Table 1
Snapper Mine and Ginkgo Mine Modification – Responses to Submissions

RE: Snapper Mine and Ginkgo Mine Modification – Groundwater Model

Regional Groundwater Effects

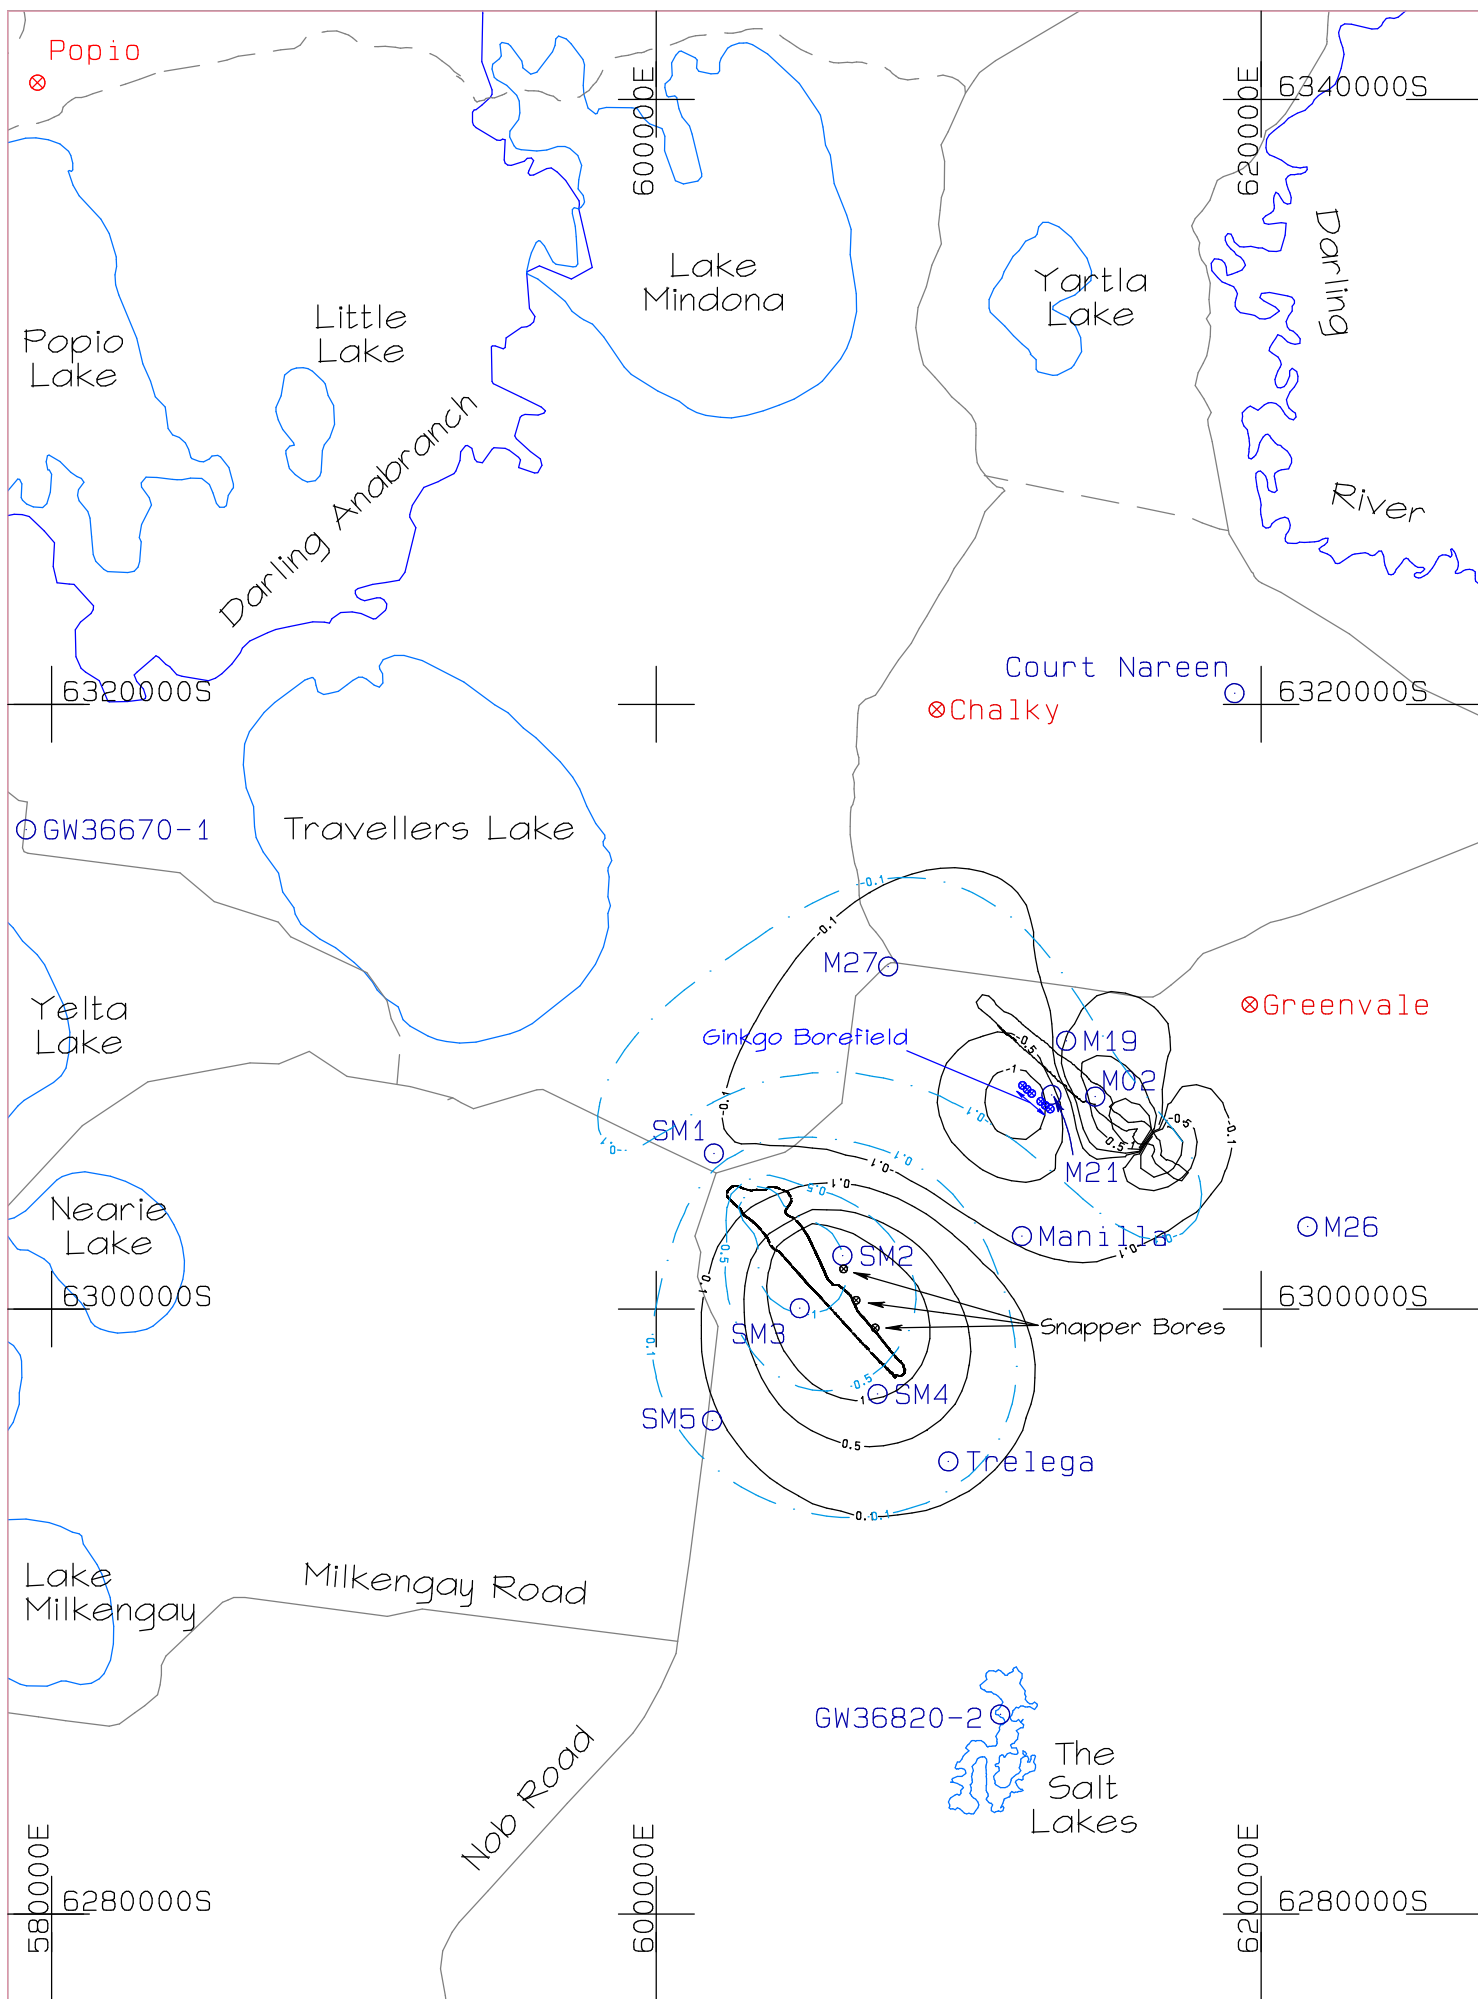
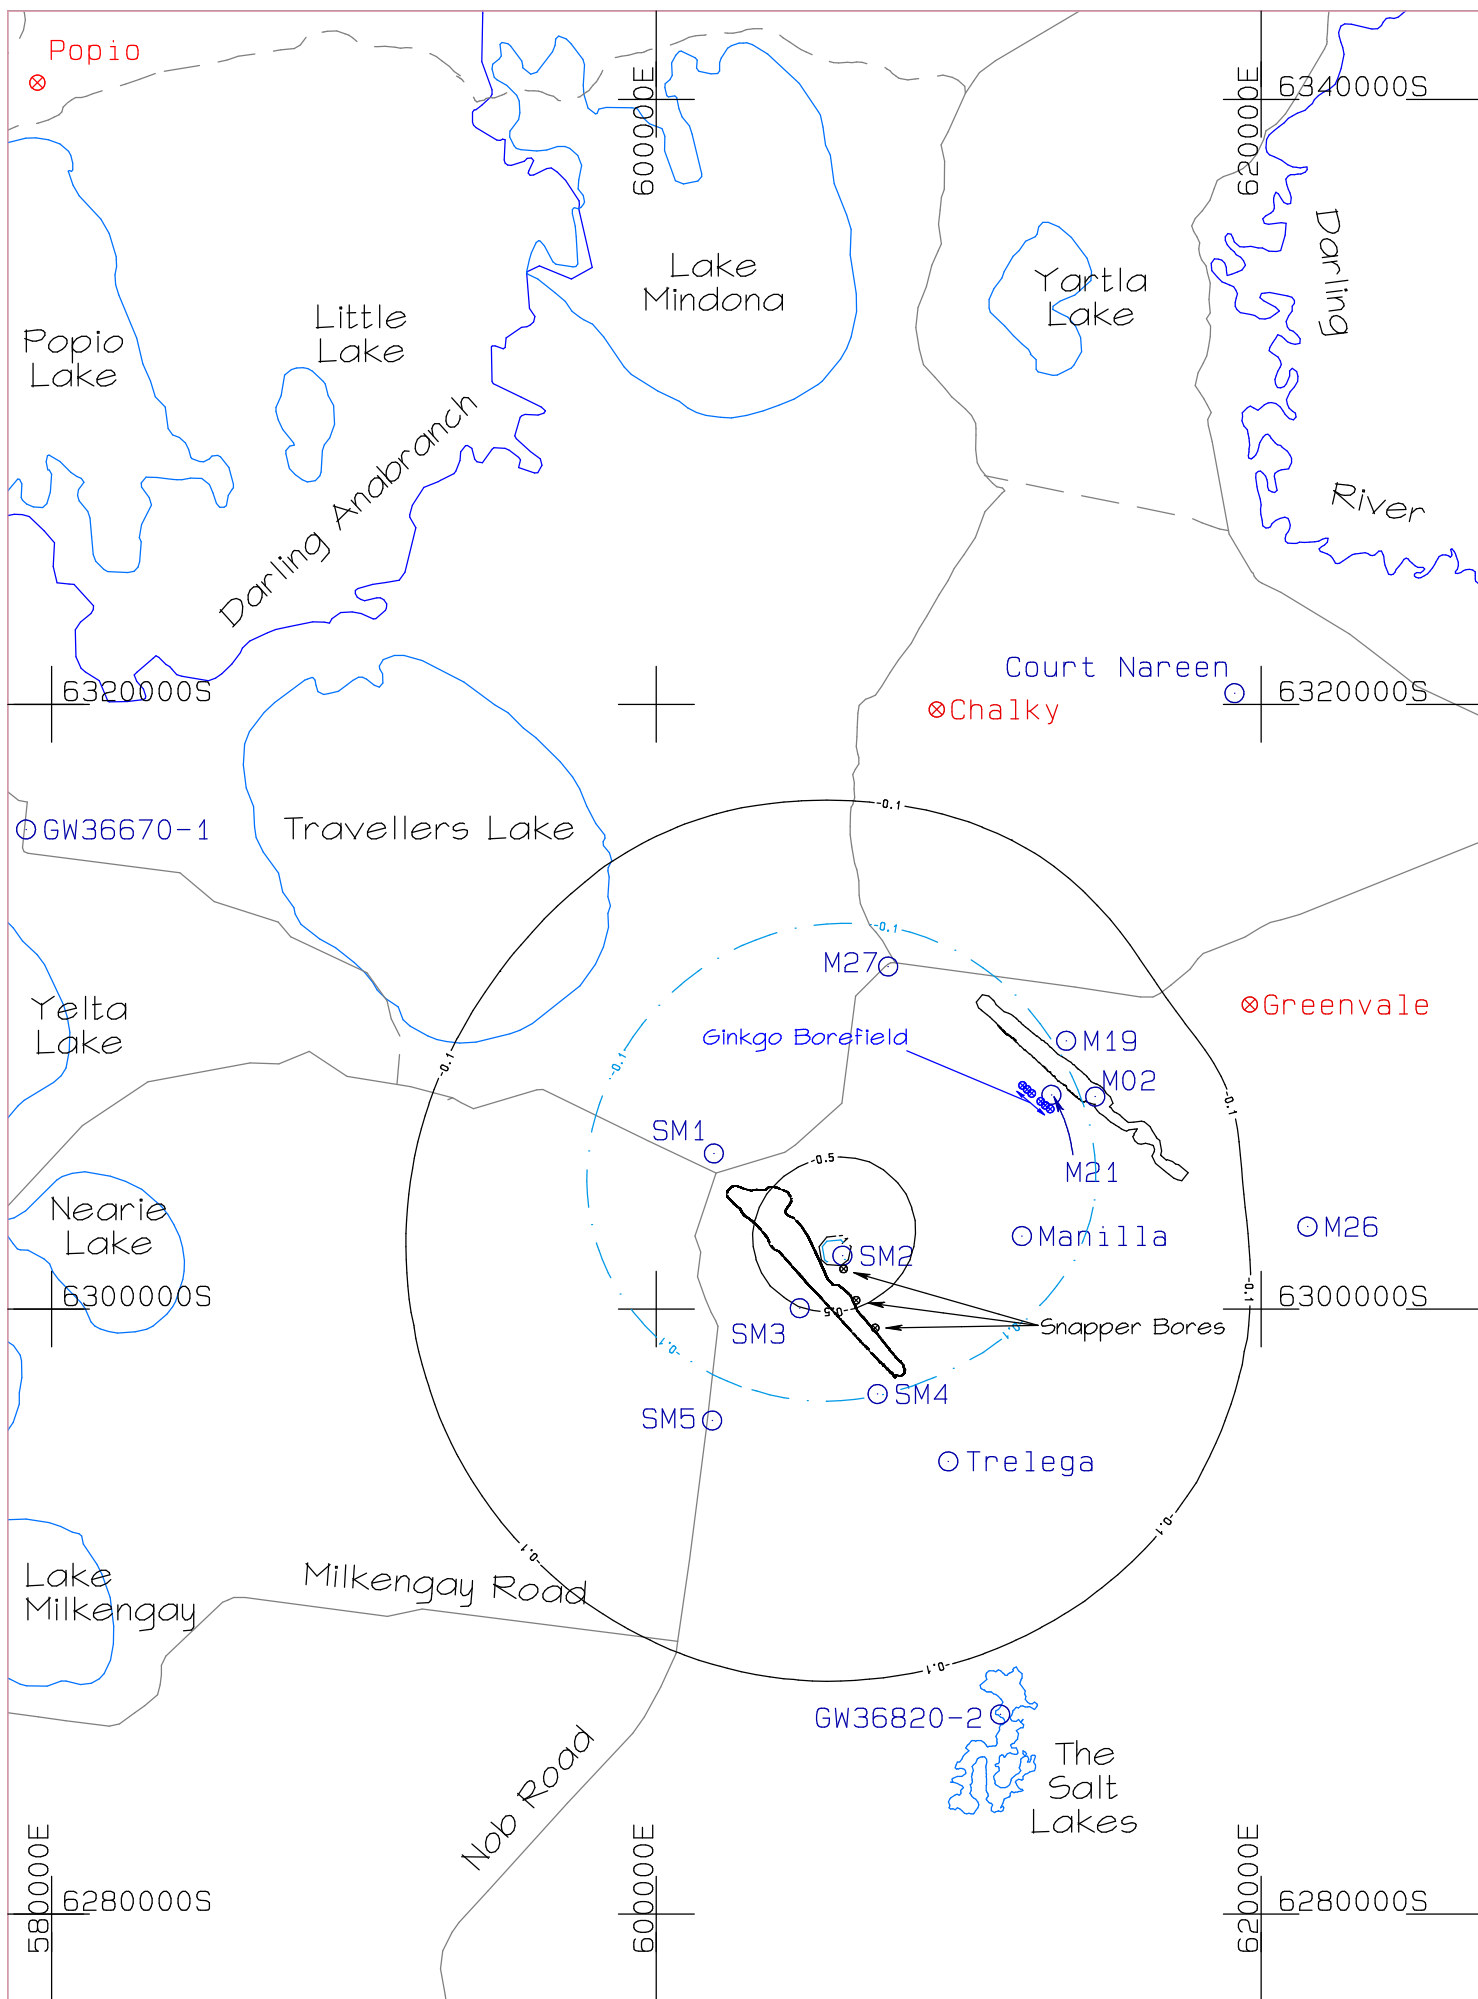
NSW Office of Water	Groundwater levels – presentation in Australian Height Datum (AHD).	<p><u>Comment</u></p> <p><i>The EA does not provide a clear indication in AHD of the existing groundwater level in the area of potential impact and the proximity of this groundwater level to current and proposed infrastructure (eg. Water disposal dam) and ground level. NOW also requires the groundwater contours presented to indicate groundwater response to be provided in AHD.</i></p> <p><u>Information Request</u></p> <p><i>The groundwater level to be presented in AHD in the area of potential impact and the proximity of this groundwater level to existing and proposed infrastructure and ground level. It is also requested for the groundwater contours utilised to represent the groundwater response to be provided in AHD.</i></p>	<p>Attachment 3 provides the desired water disposal dam water levels for each year of the Snapper Mine in relative level (RL) metres (m) Australian Height Datum (AHD). The natural ground level at the site for each year of the Snapper Mine is also provided in Attachment 3 in RL m AHD.</p> <p>The modelling indicated a maximum mounding of the groundwater level beneath the water disposal dam to approximately RL 47 m AHD, (i.e. approximately 13 m above the existing watertable [approximately RL 34 m AHD]).</p> <p>Attachment 4 presents the groundwater contours presented as Appendix C of the Hydrogeological Assessment revised to show groundwater levels in RL m AHD.</p>
